Mariah Trail, Filing No. 1, SF-23-17

Please accept the following comments from El Paso County Public Health regarding the project referenced above:

Mike McCarthy
El Paso County Public Health
719-332-5771
mikemccarthy@elpasoco.com
21July2023

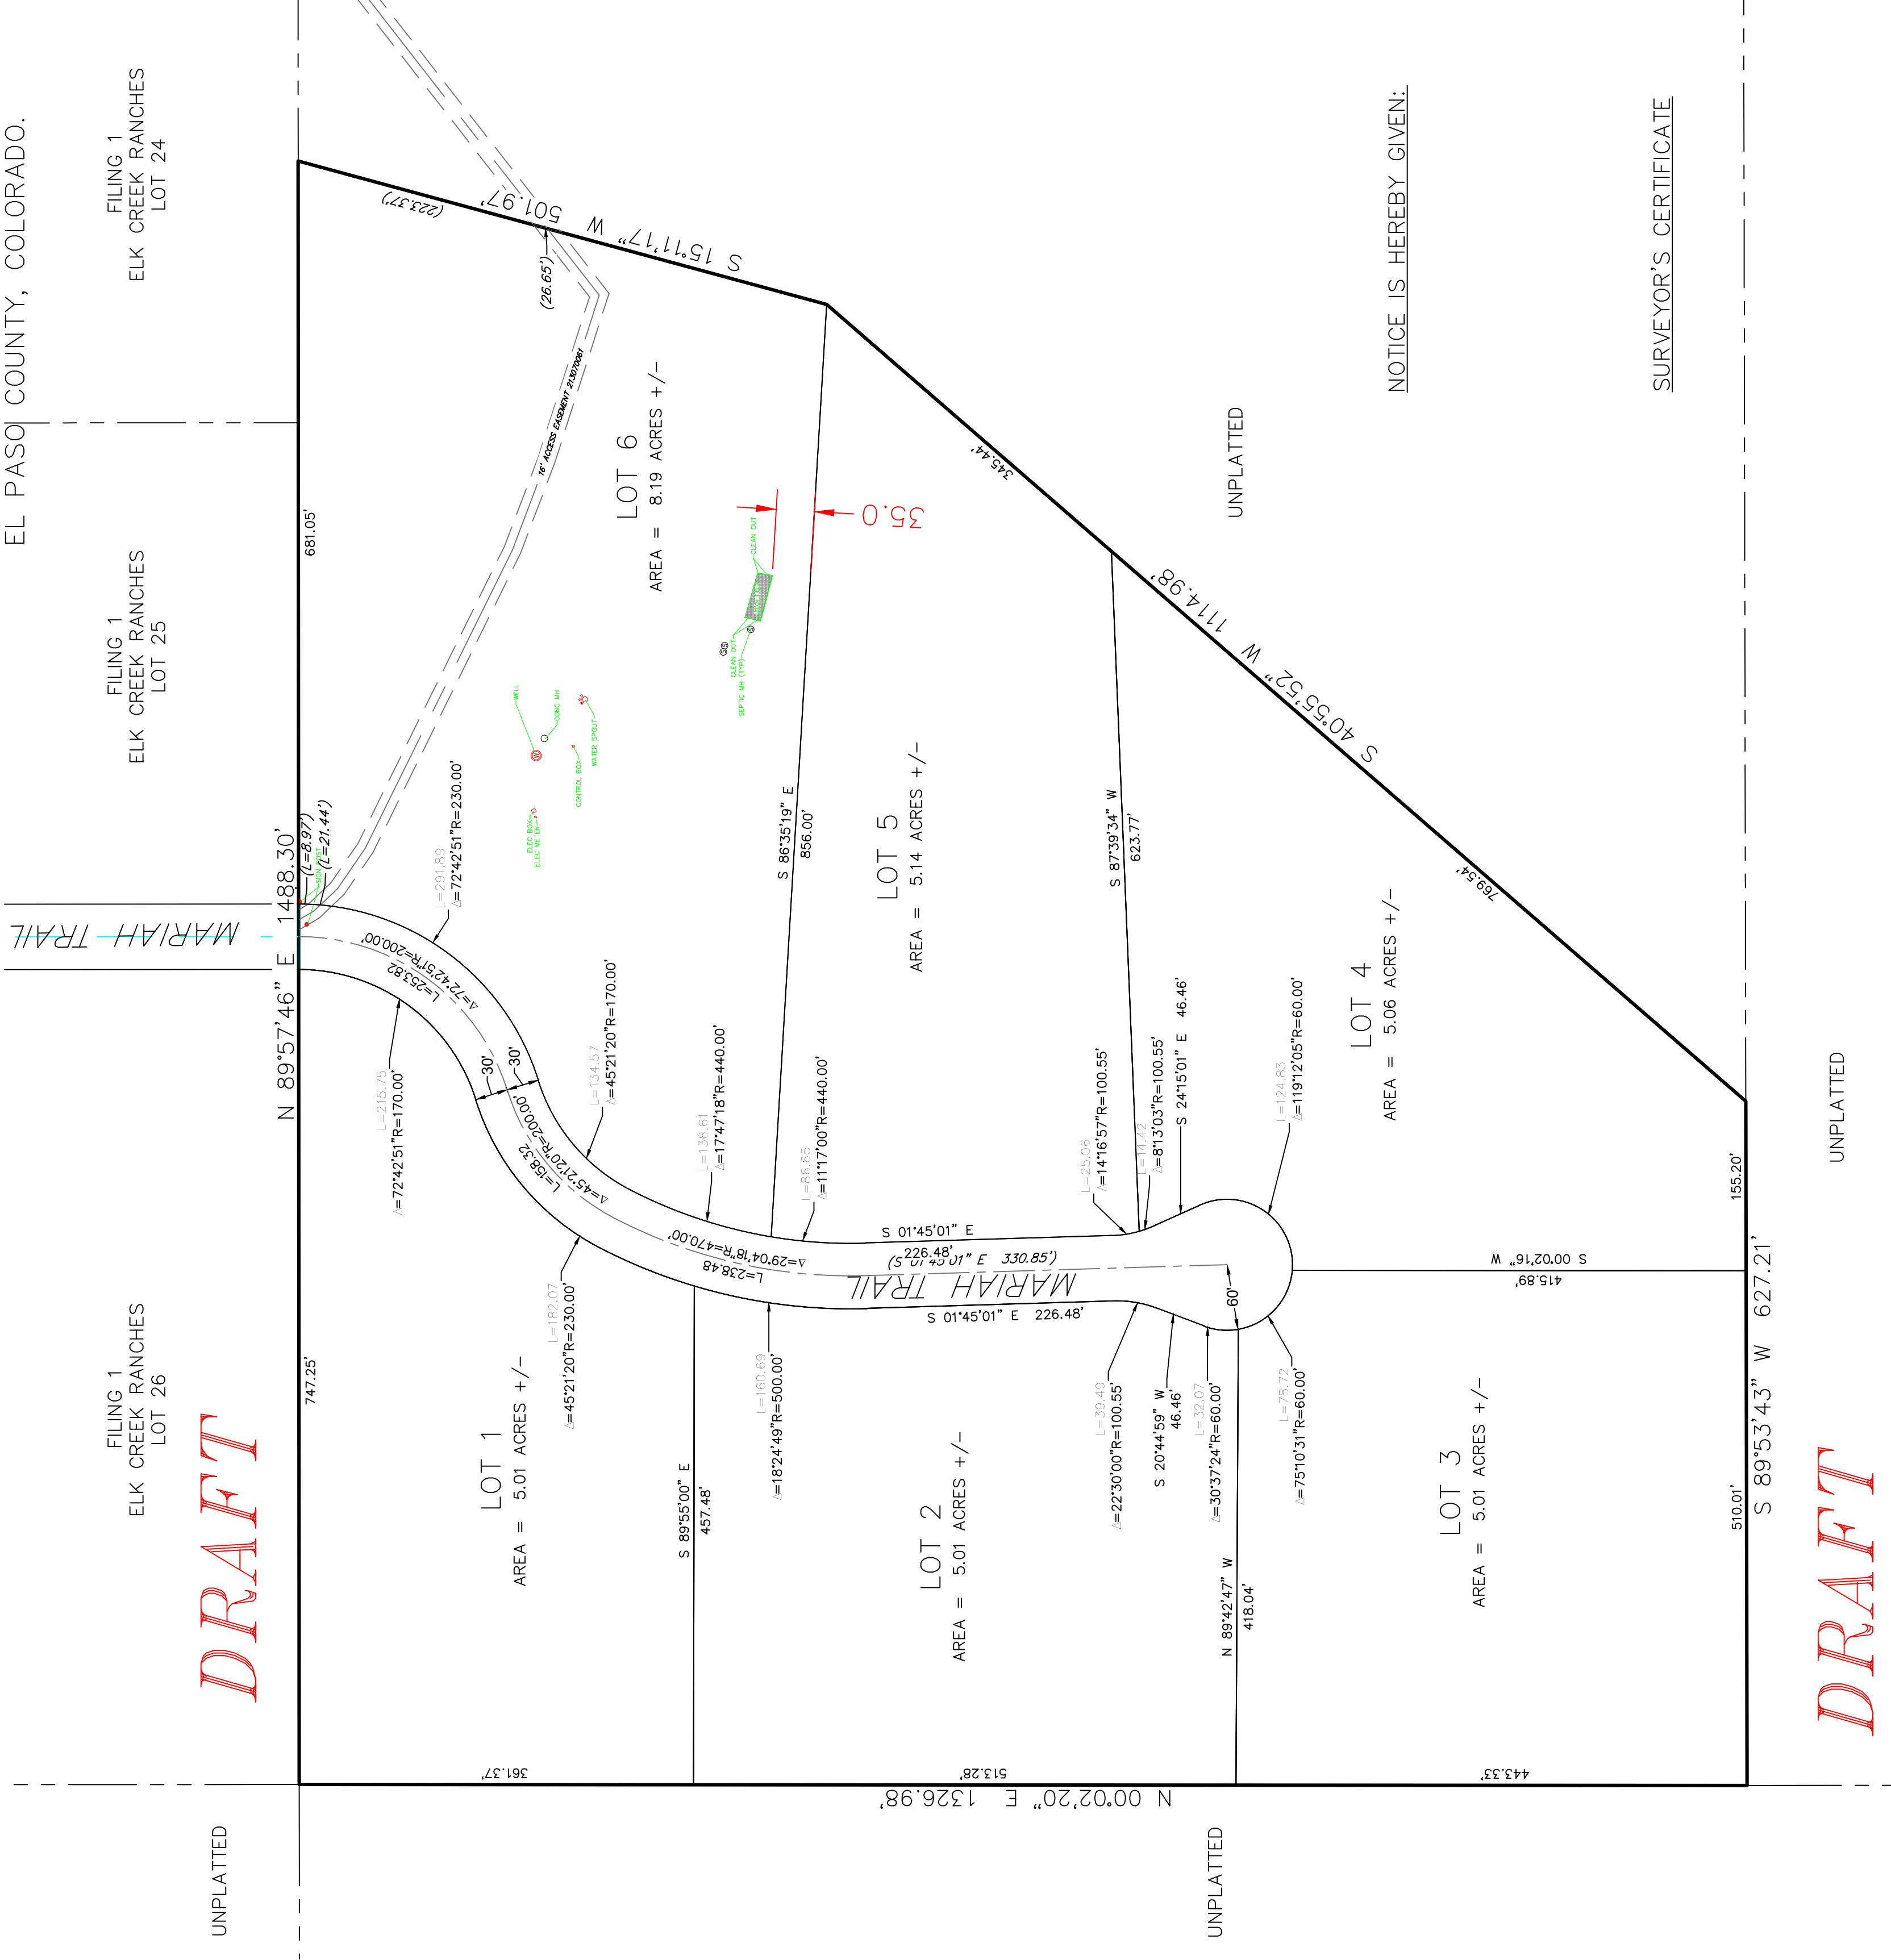
- The above-mentioned soils reports did not provide soil test evaluations as required by the Land Development Code or El Paso County Public Health. Soil profile test pit excavations are required and only soil boring test results were submitted. Please submit a minimum of 2 soil profile test pit excavations for review for suitability of the site for OWTS use to be evaluated.
